BOTLEY WEST SOLAR FARM – EN010145

Section 51 advice regarding draft application documents submitted by Photovolt Development Partners (PVDP) on behalf of SolarFive Ltd

On 14 May 2024 Photovolt Development Partners (PVDP) on behalf of SolarFive Ltd submitted the following draft documents for review by the Planning Inspectorate as part of its Pre-application Service¹:

**Illustrative Masterplan**  
**Figure 2.2A**  
 Central Site Area 1 of 4

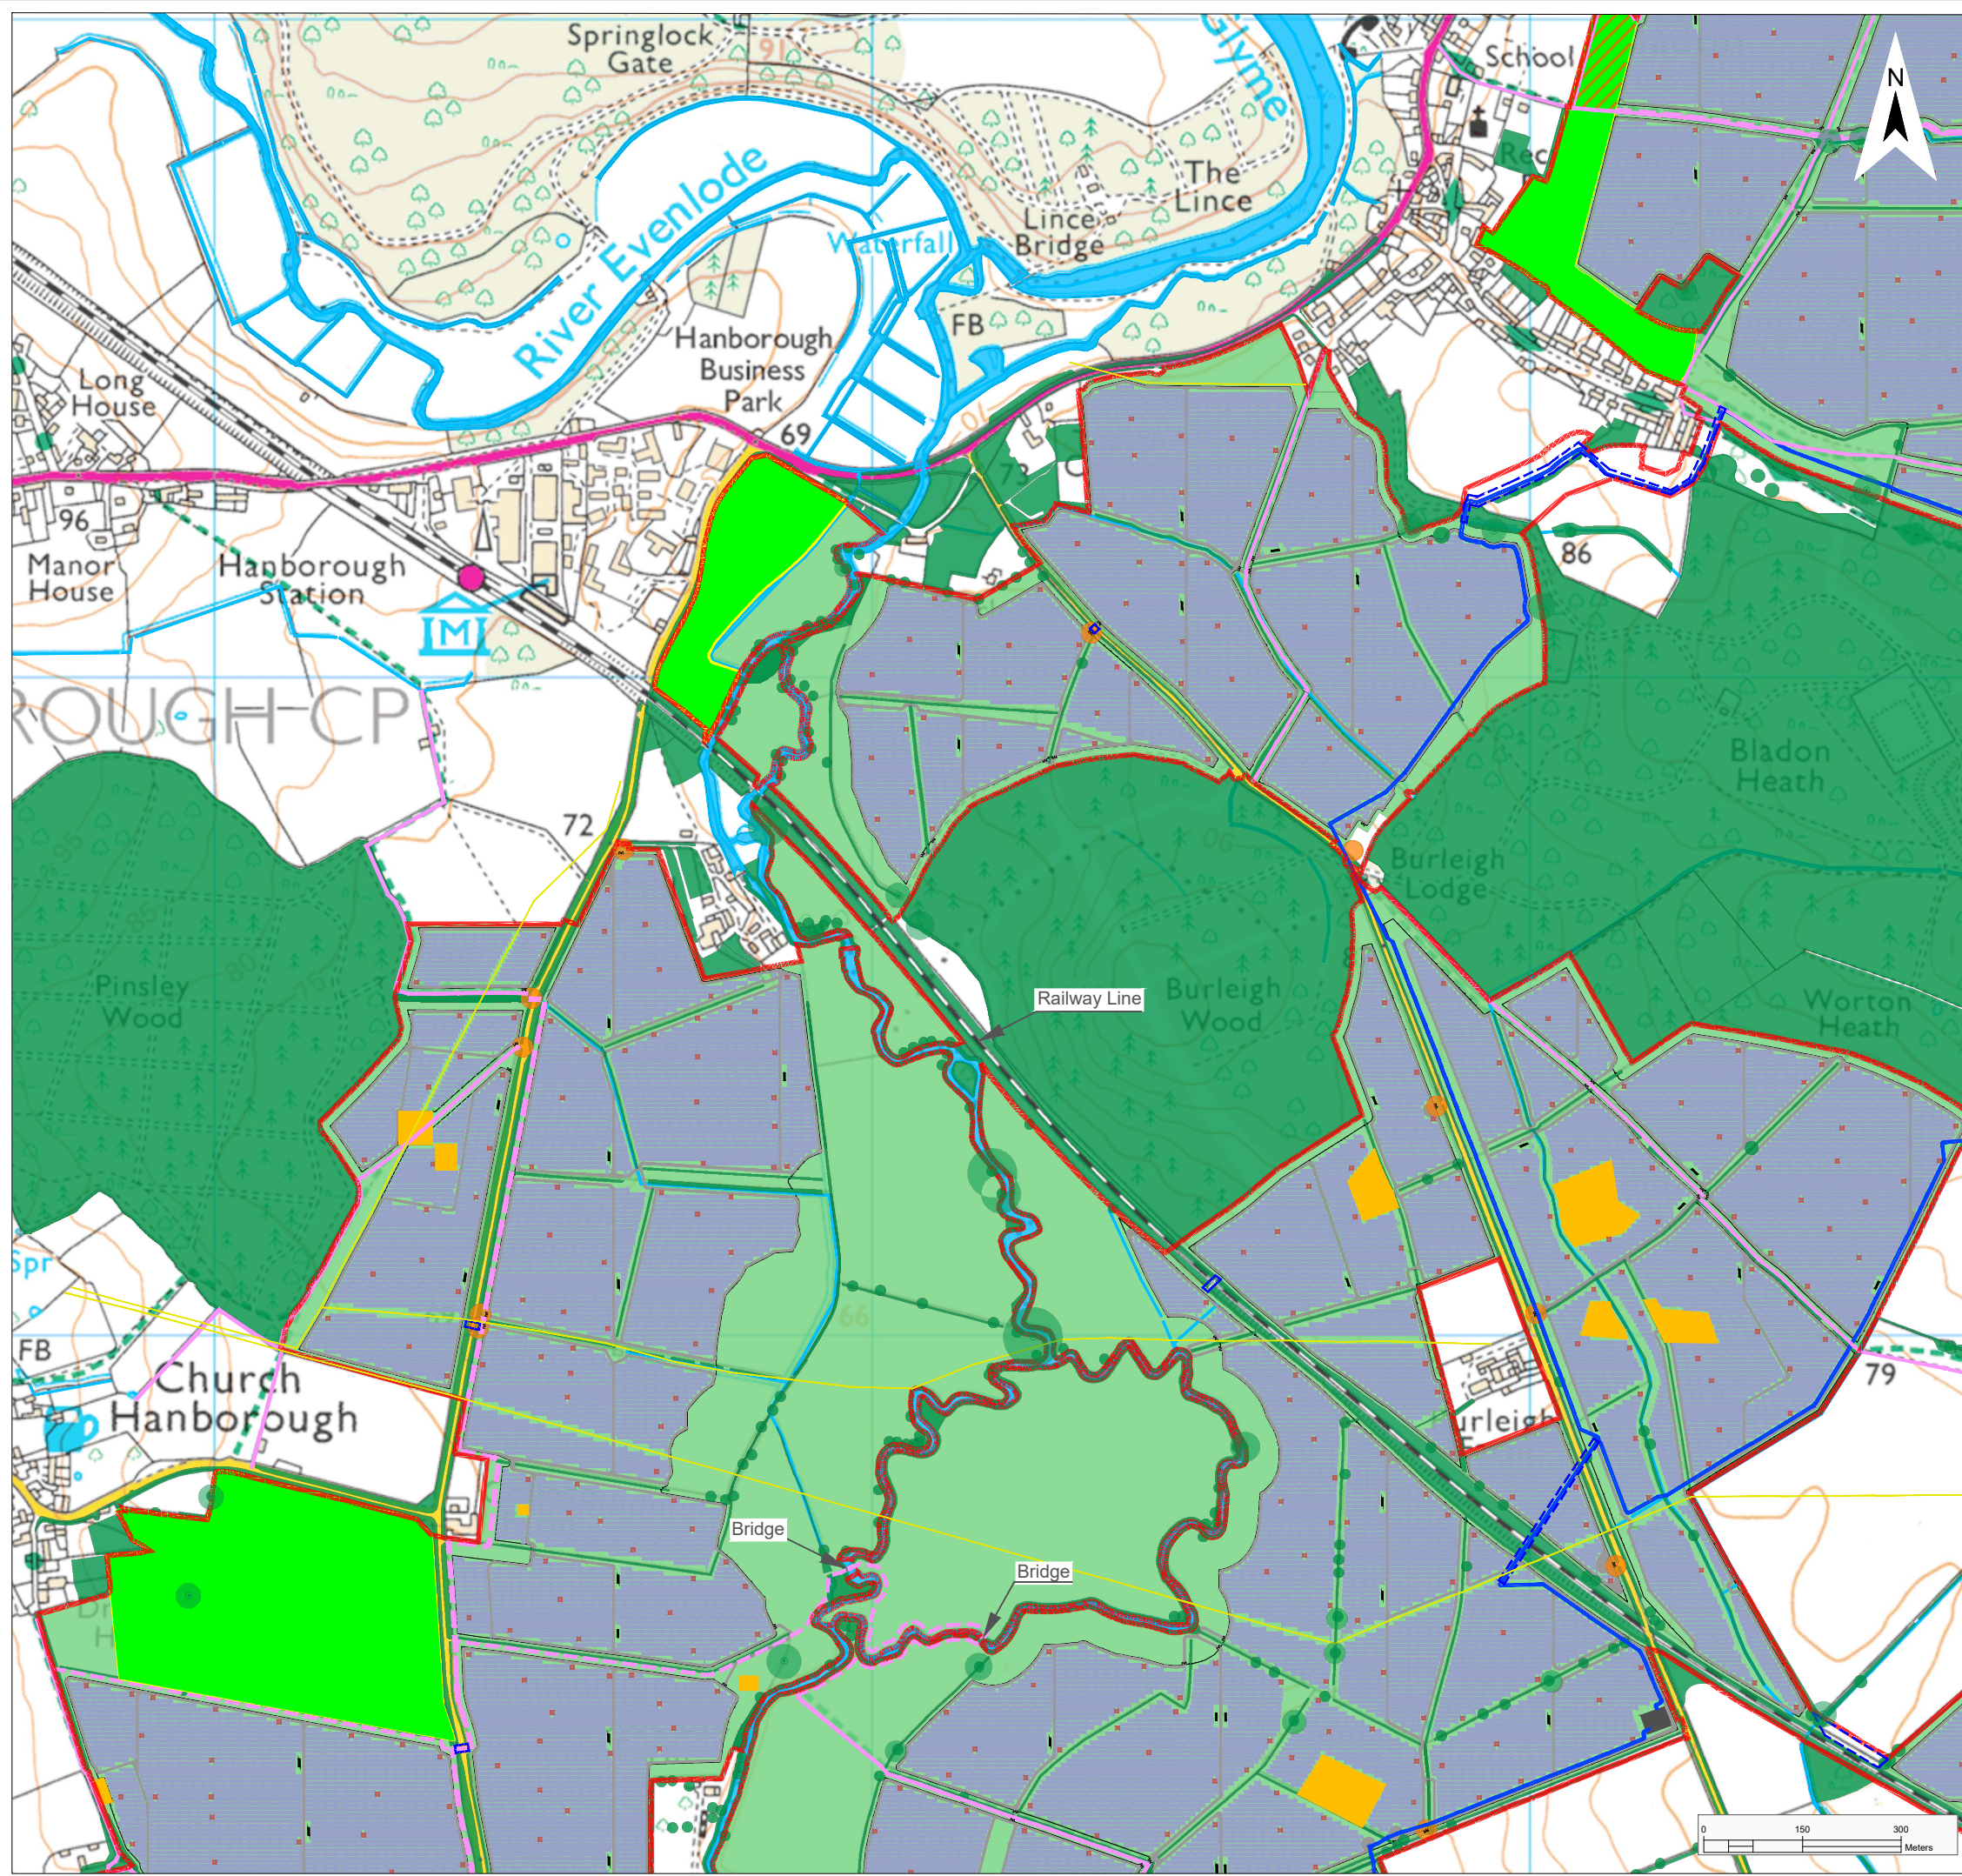
Ref No.	Paragraph/ Section	Comment/Question
5.	Masterplan Overview - Figure 2.2a Central Site Area 1 of 4	The Applicant should ensure consistency across their application documents upon submission and make clear what the purpose of the 'Skylock Plots' will be.

**Illustrative Masterplan**  
**Figure 2.3**  
**Southern Site Area**

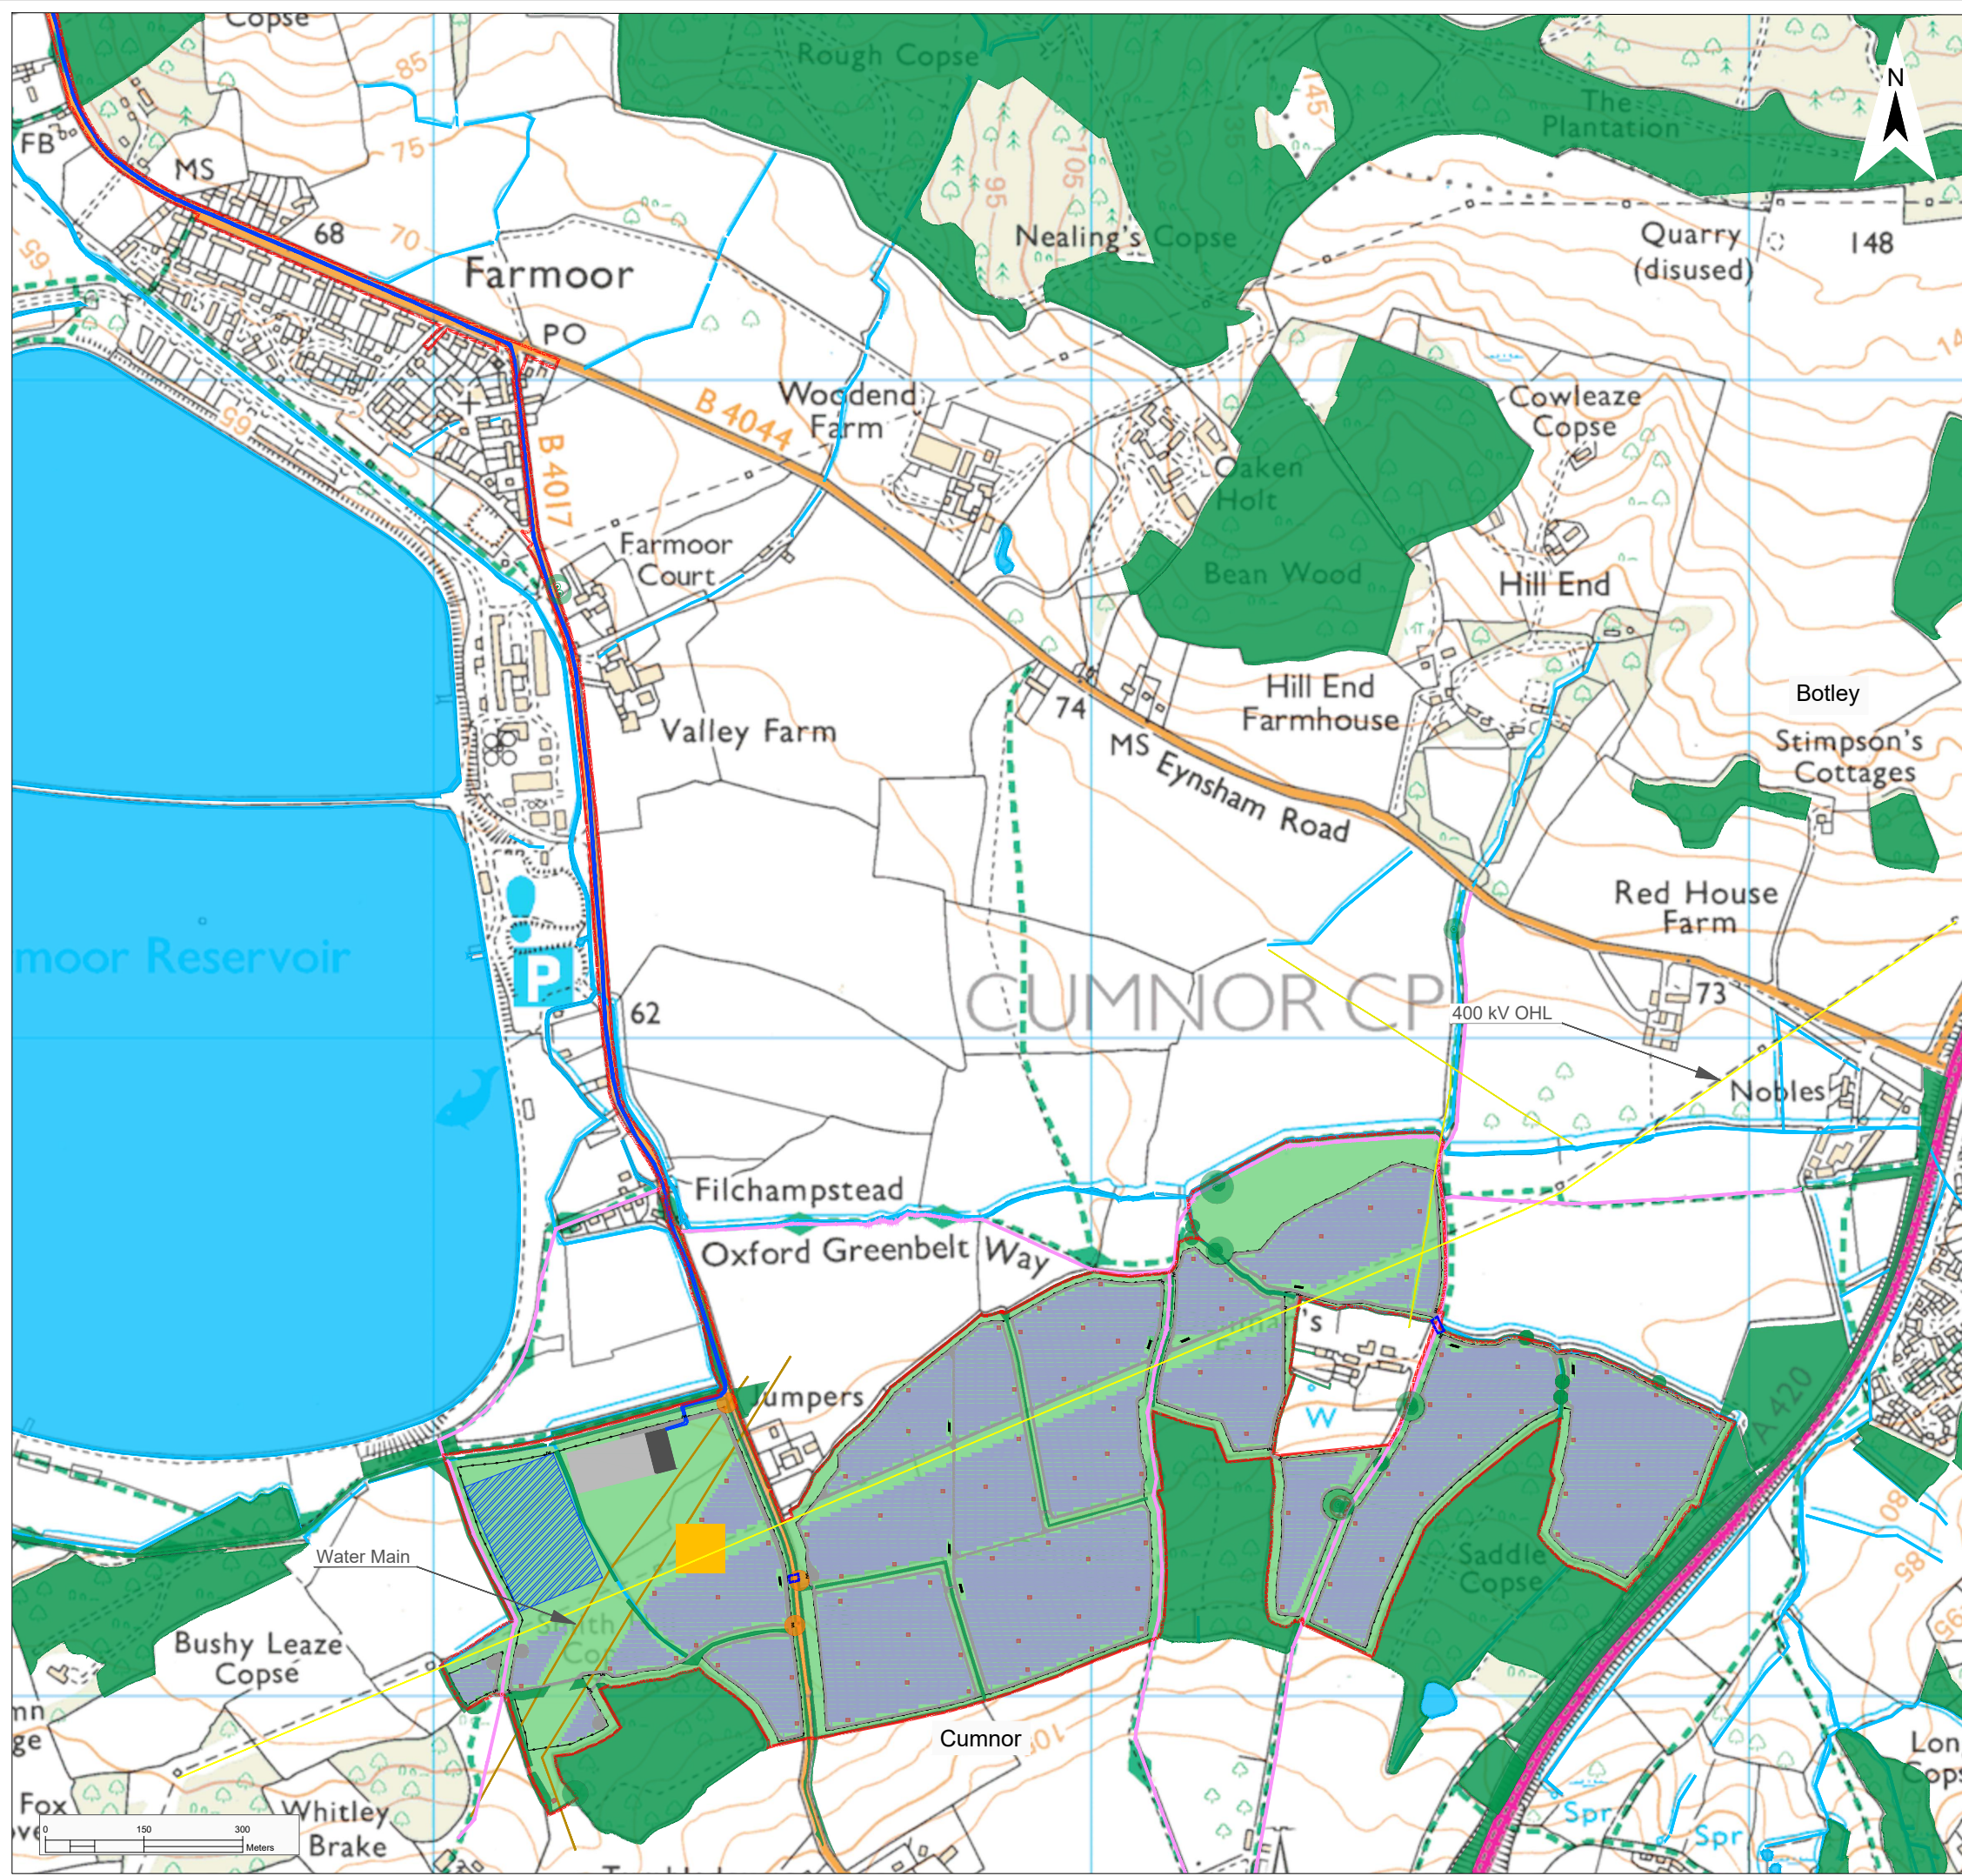
Plans and Figures		
Ref No.	Paragraph/Section	Comment/Question
6.	Temporary Facilities - Figure 3.1a Northern Site Area 1 of 2	The figure inset showing the location of the temporary haul road in the northern site area is blurry / illegible.
7.	Illustrative Masterplan - Figure 2.3	The “Proposed Infrastructure and Land Use Elements” section of the legend for this figure includes an “Educational Area” however there is no reference to or explanation of what this comprises in the project description.
